Comments on your proposals;

Paul Cann
Principal Engineer (Drainage)

Subject: A/144/19/DOC Land East of New Place Nursery, Arundel Road, Angmering

### Attenuation tank using polystorm-r geomodular units

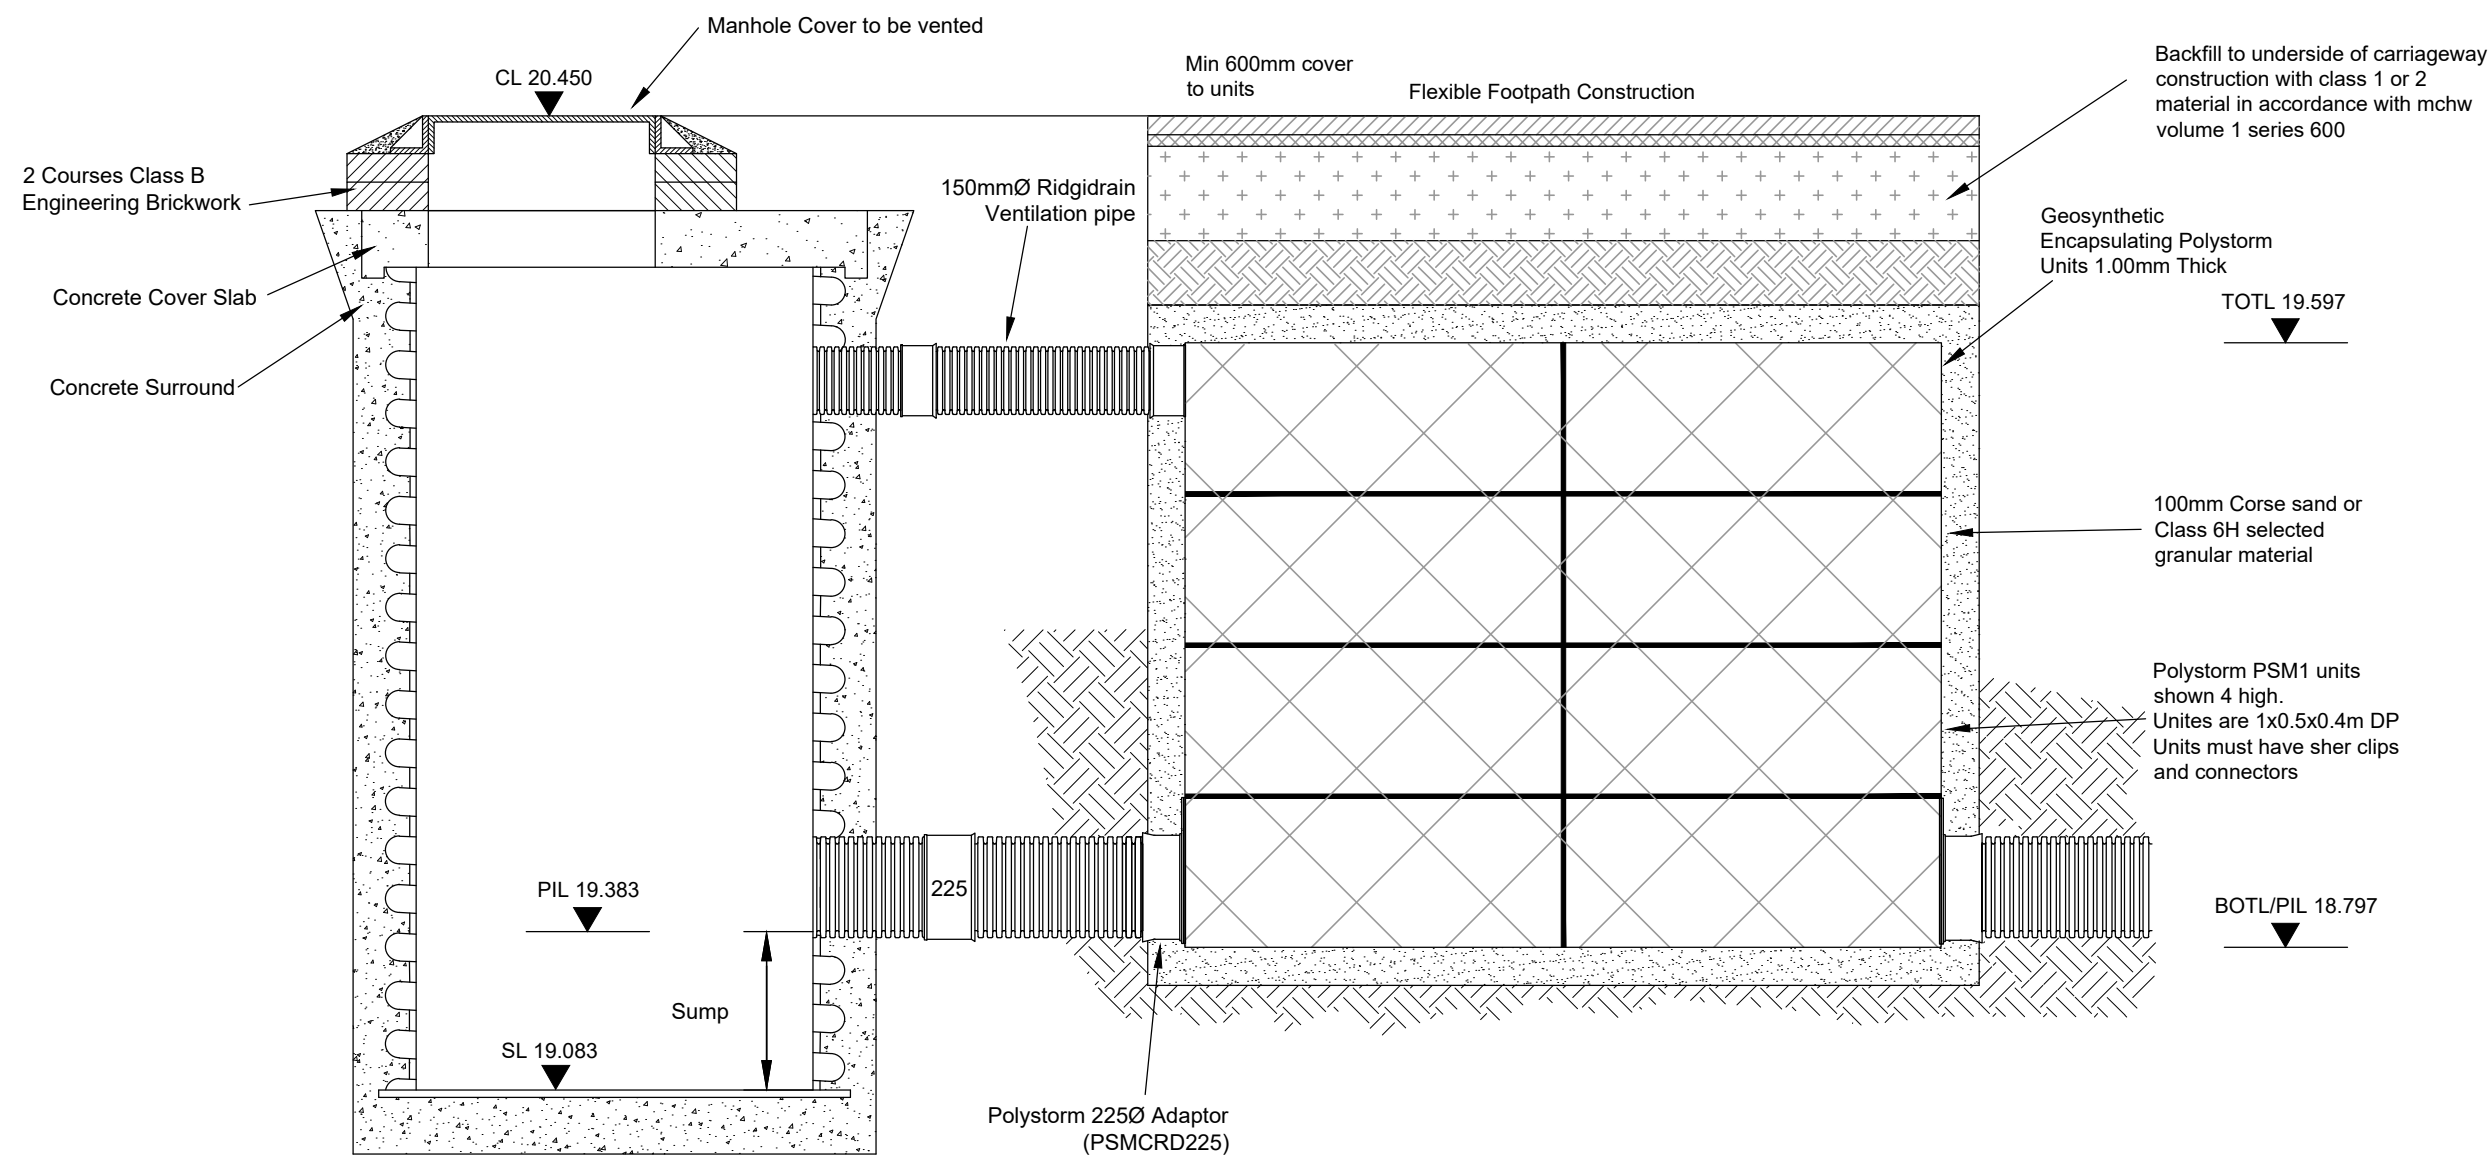
20. Geosynthetic encapsulating polystorm unit – provide technical brochure extract detailing the tanking spec.
21. Add general note regarding manhole cover grades ie. grade and use.

### Resin bound private driveway construction

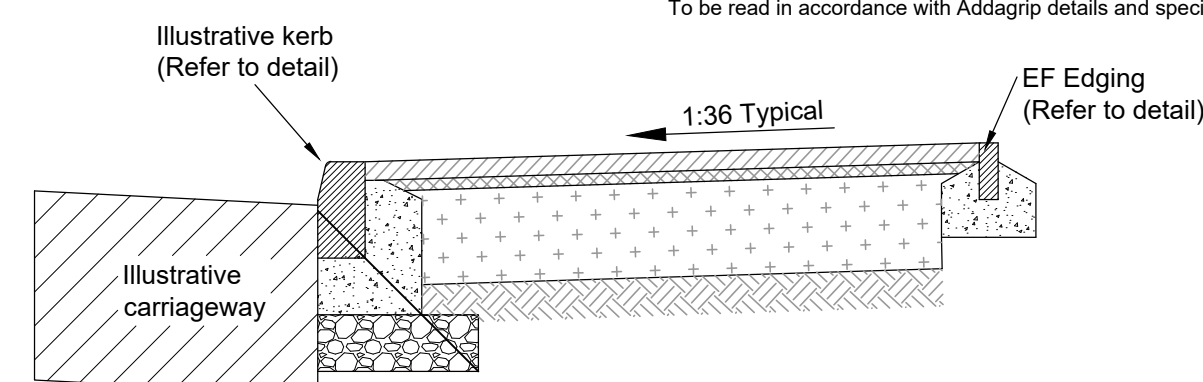
10. Show permeable paving finished surface levels and base levels on plan.
11. Permeable paving – provide permeable geotextile layer between binder course and sub base to prevent migration of fines.

25. Driveways are falling towards the properties. Whilst the sub base water is being collected by fin drains, additional measures need to be put in place to protect the property/garages should the permeable surface become blinded and ineffective. I would suggest a decent channel drain.

Rev	A	Services	07.05.20
Drawing Title			
Detailed Tree Protection Plan			
Client	GD Group	Date	22.10.19
Project	Arundel Road, Angmering	Drawing Ref	DTPP
Scale	1:250@A2	Job Number	1911
Drawn	JLD		
The Urban Forest Consultancy			
W www.ufctrees.co.uk E joanna@ufctrees.co.uk M 07968021337

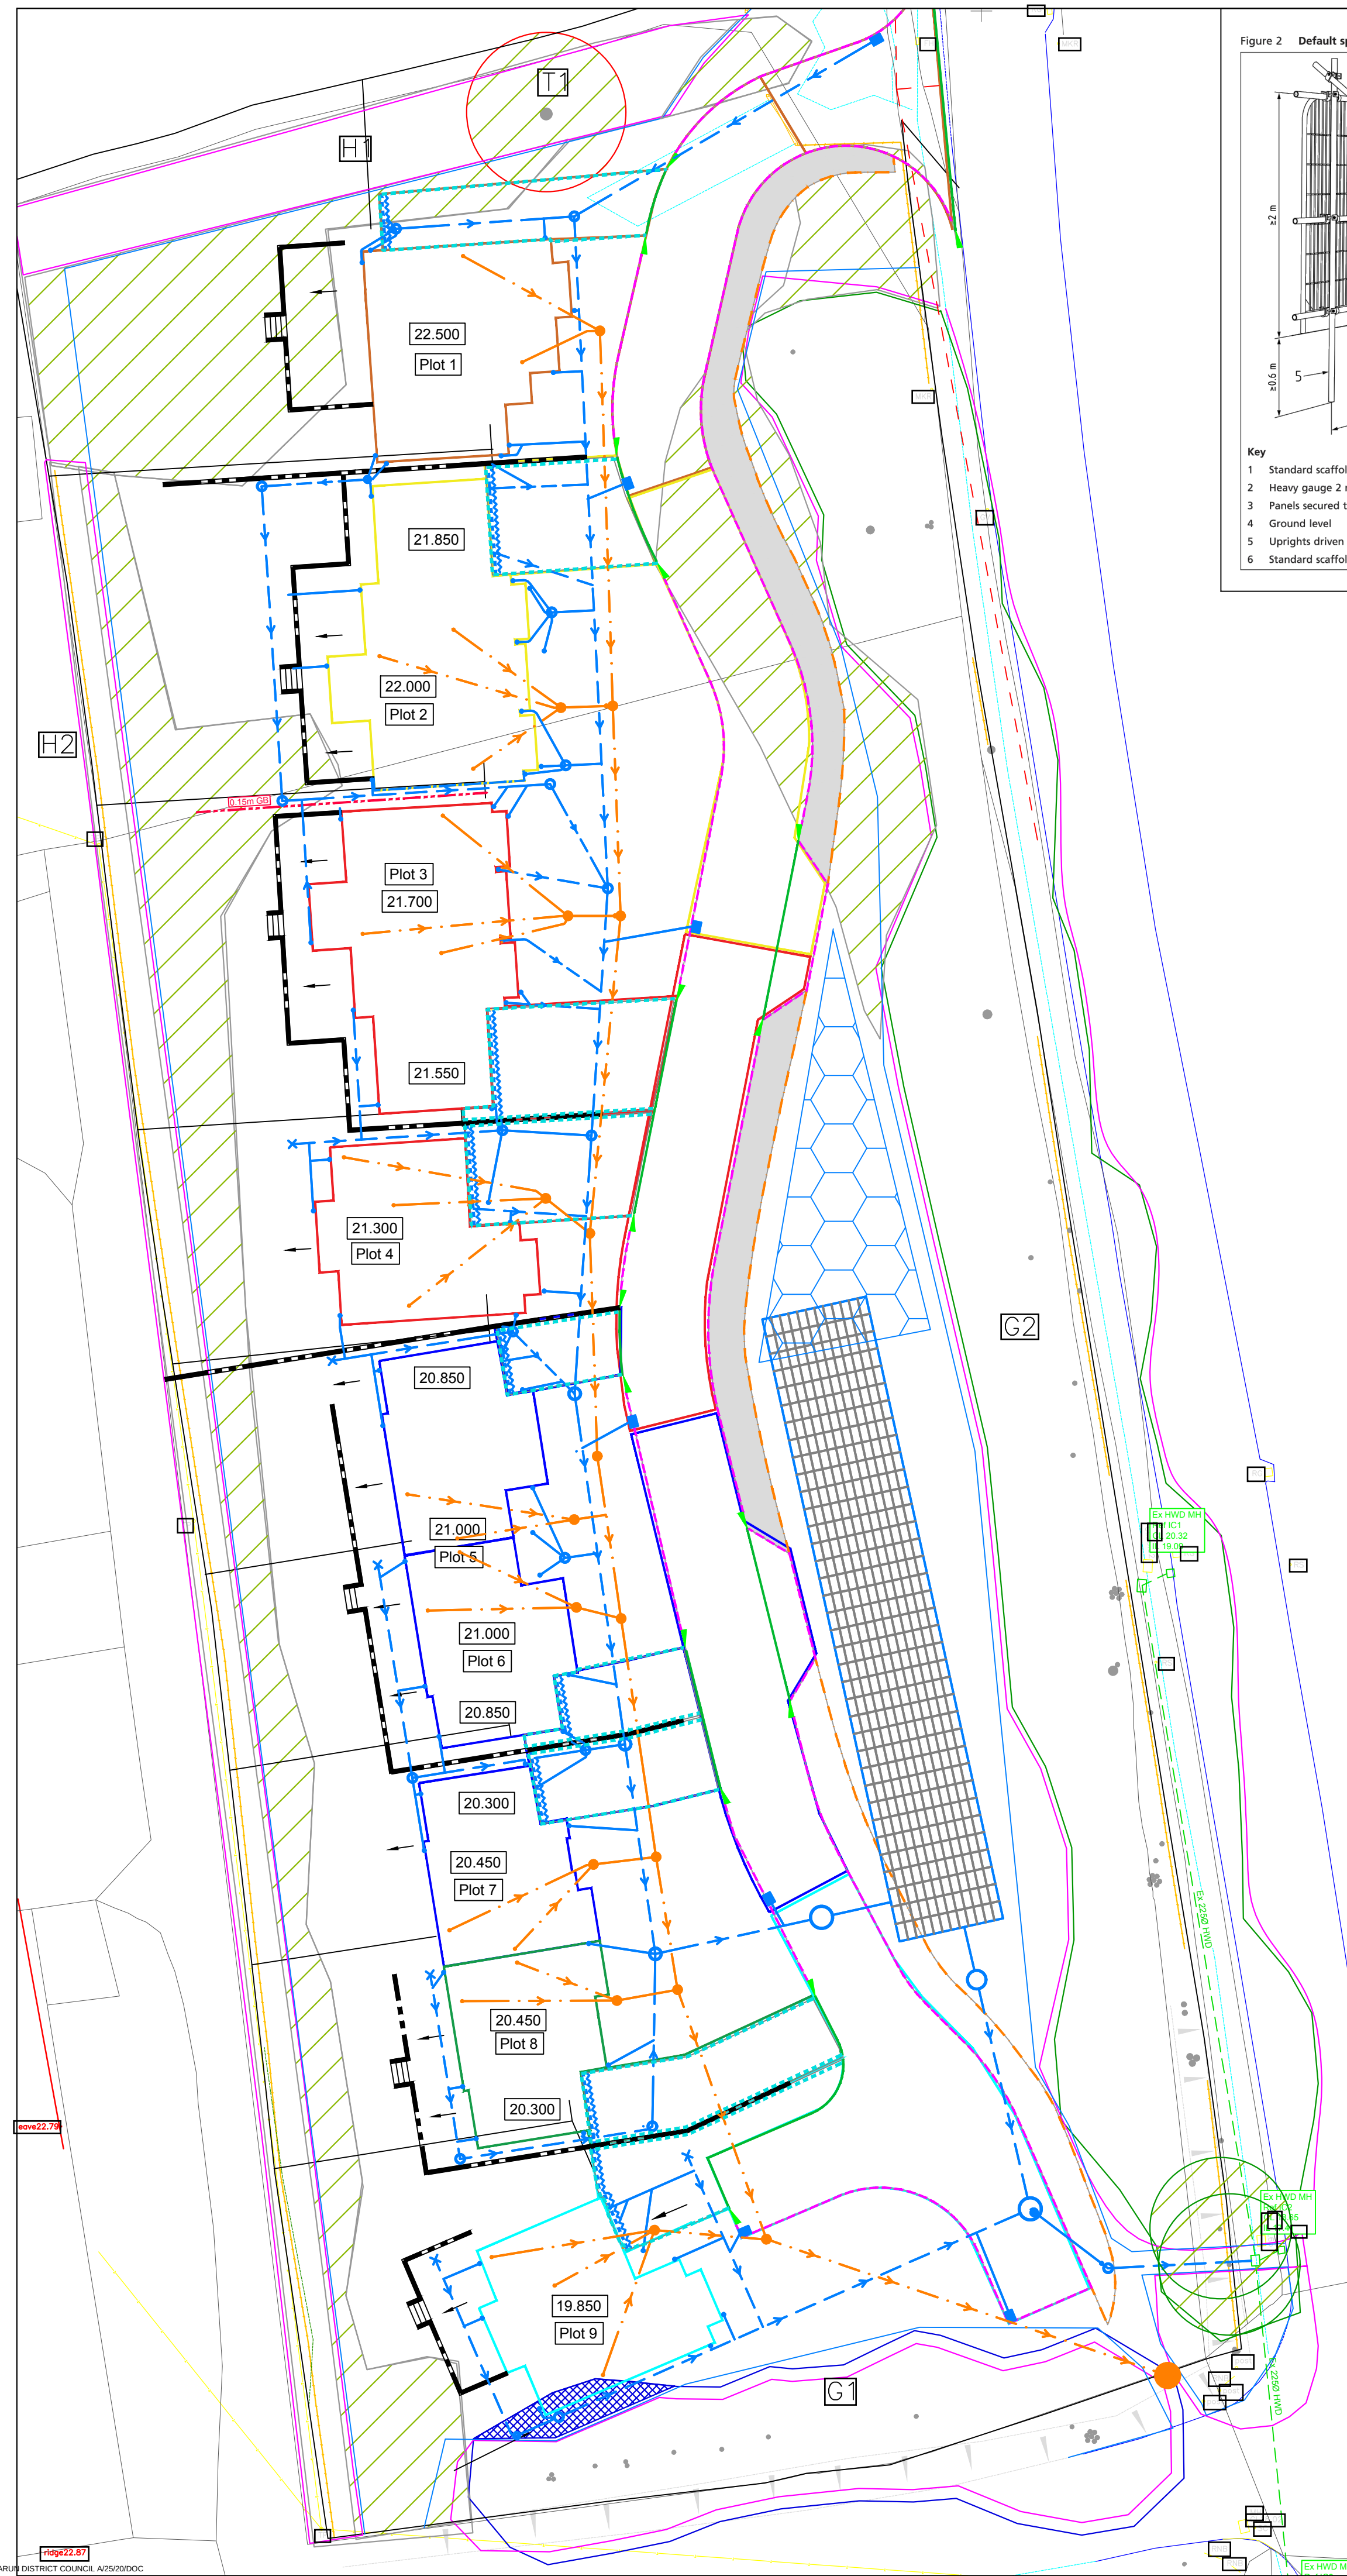
2. Please provide confirmation from our tree officer confirming that the tank is outside the existing and future root protection zones.
3. Specify tank inlet and outlet invert levels on the layout plan.

6. Add suitable note 'all connections not to manholes to connect via oblique junctions as per your construction details'.
7. Pipes downstream of tank encroach into root zones. Please adjust as necessary to ensure they are not within existing or future tree root protection zones. Length S10 to HWD will probably need to be lengthened to achieve this and will require a 150mm concrete bed and surround (add note) to protect against root intrusion. Please indicate the clients proposals (on the plan) in respect to the vegetation in that area.

12. Show finished road levels.
13. Trees on southern boundary – pipes are within the root zones here – indicate proposals for these trees. Further discussion will need to be had and these will include our tree officer.
